Text of email from Tim Townsend (WSCC) to Michael Eastham (ADC) dated 18.03.2022

Thank you for your recent consultation about landscaping for the development proposed under the above planning reference at former Toddington Nurseries Site.

A088461 LA300-303[W]v2.dwg

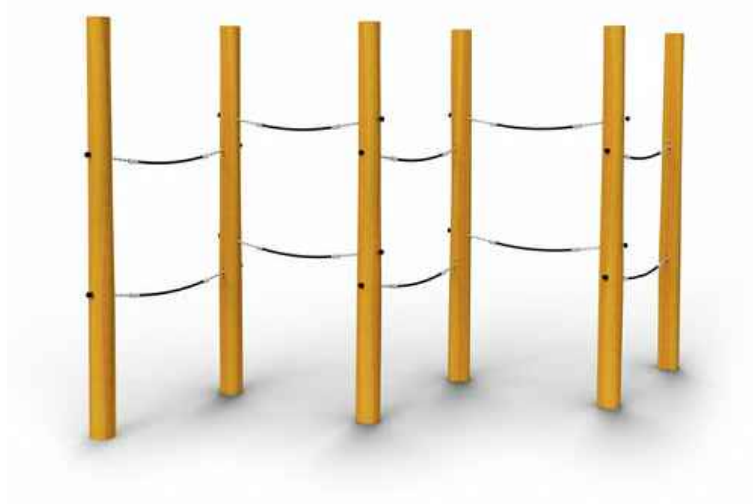
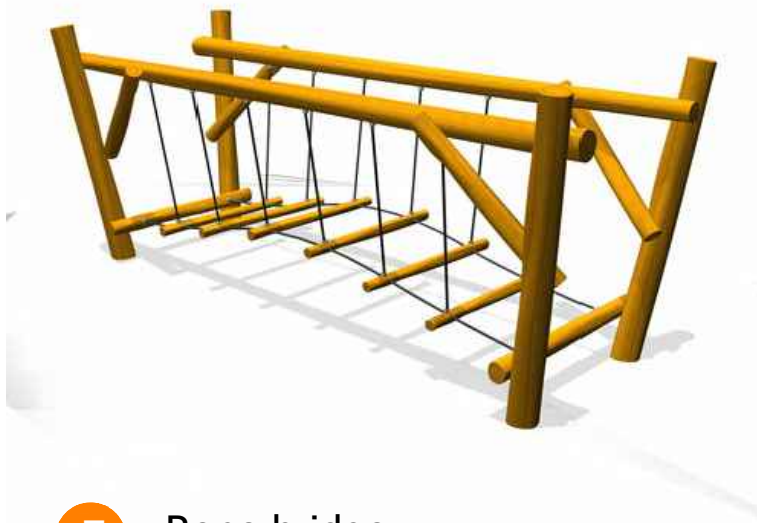
2. (Julie Bolton's comments) - According to the latest plan, A088461 LA300-303(W) v2/dwg dated 27.10.21, there's meant to be some retained vegetation opposite Hinchcliffe Close (although there's hardly any appreciable difference between the symbols for retained and removed vegetation) but it doesn't look like it from last April's Street View. Please confirm (oh, and ignore the paragraph numbers immediately to the left of the photo and the plan extract below as they appear to be caught in the 'snips' and I can't remove them):

- 3.
3. The tree protection plan is conflicted, since the drawing shows some vegetation to be retained along the road frontage with ground protection, but the tree schedules show everything is to be felled except 3 hedgerows which I can't find on the drawing. Presumably the Leyland Cypress (just seen in the background) has been removed too? Please confirm.
